8th November 2023

**Planning Application 23/02338/OUT – Land West of Oxford Close and North of Corner Farm,
Station Road, Kirtlington**

Outline permission for the erection of 15 detached and semi-detached single and two storey dwellings (including affordable housing)

Drawing Title:
 PROPOSED
 SITE PLAN
 COLOUR
 (ILLUSTRATIVE)

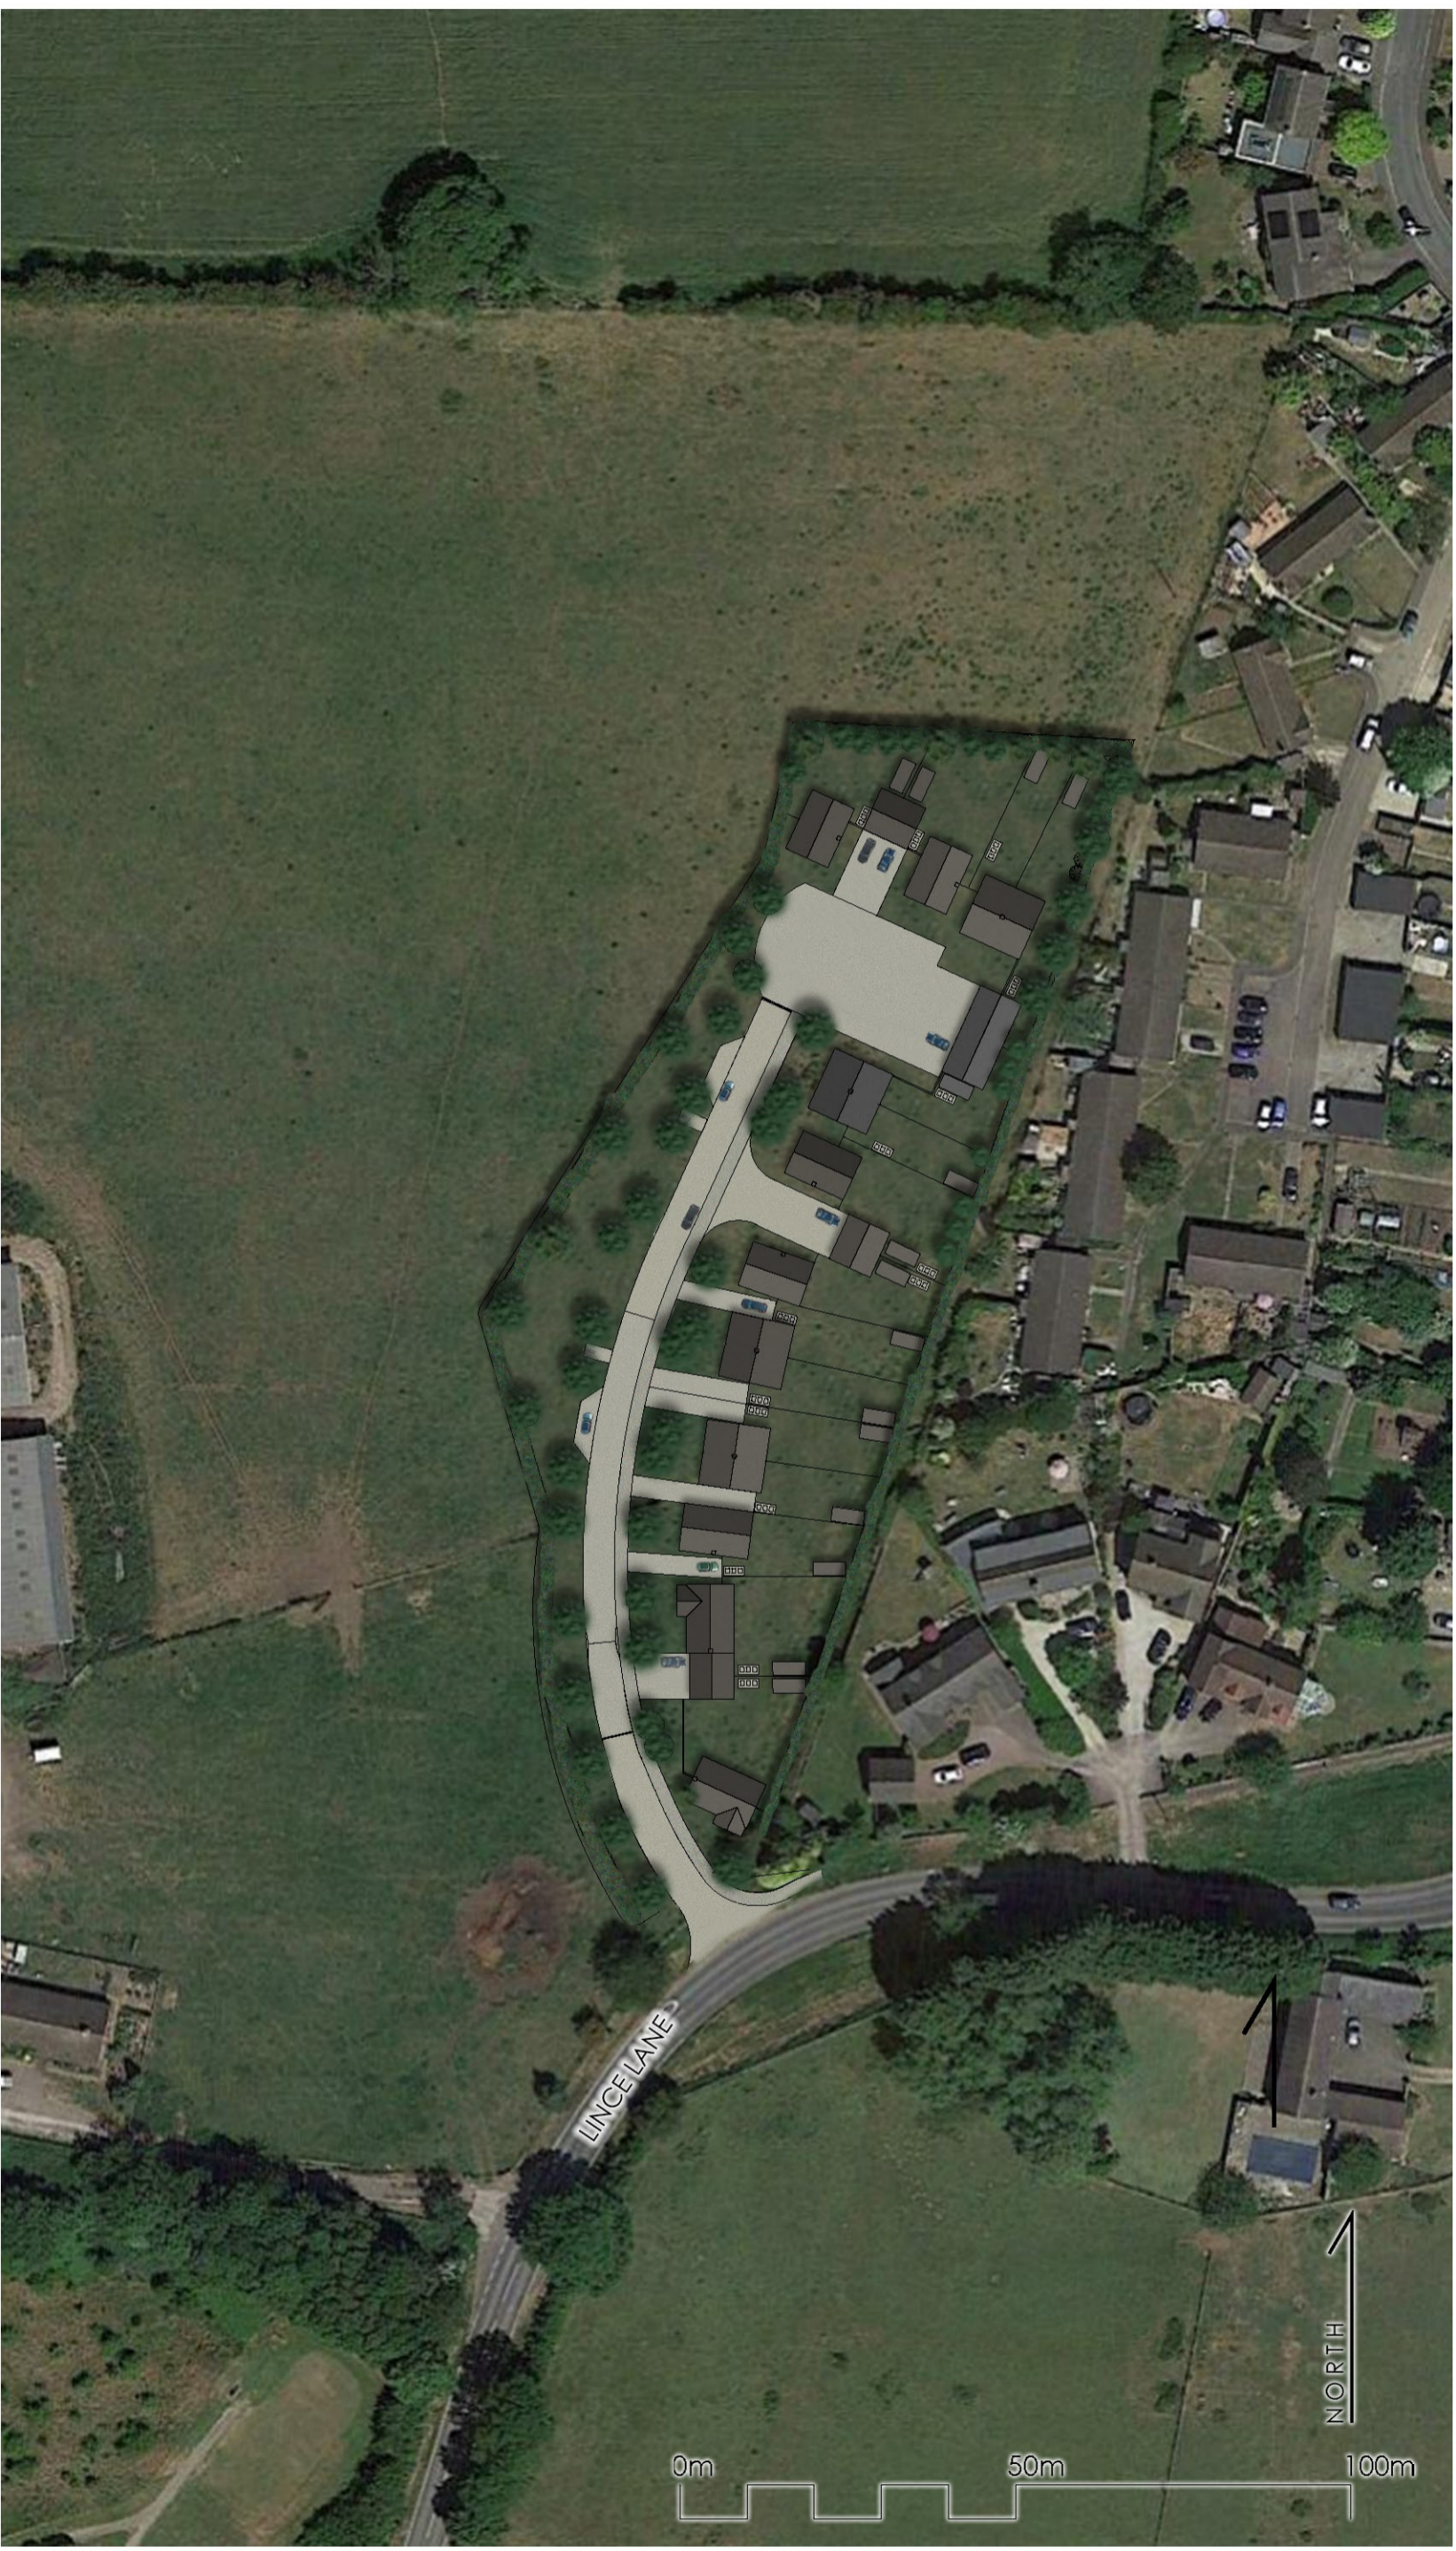
PD1 Development at Category A Villages. Criterion c) is not met. We consider that the established western edge of the village adjoining open countryside would be disrupted rather than enhanced by the proposed development.

PD4 Protection of Important Views and Vistas. This policy contains a requirement to demonstrate sensitivity to important views and vistas referenced in Table 4. Table 4 c) refers to Appendix K of the MCNP p.43, in respect of Kirtlington, where it is stated: “There are attractive views out across the wooded Cherwell Valley from the public right of way along the western edge of the village, and the orientation of this footpath directly along the straight western edge of the village limits the visual influence of settlement on the view.” The proposed scheme would destroy this view from the footpath. The proposals do not meet the requirement of this policy.
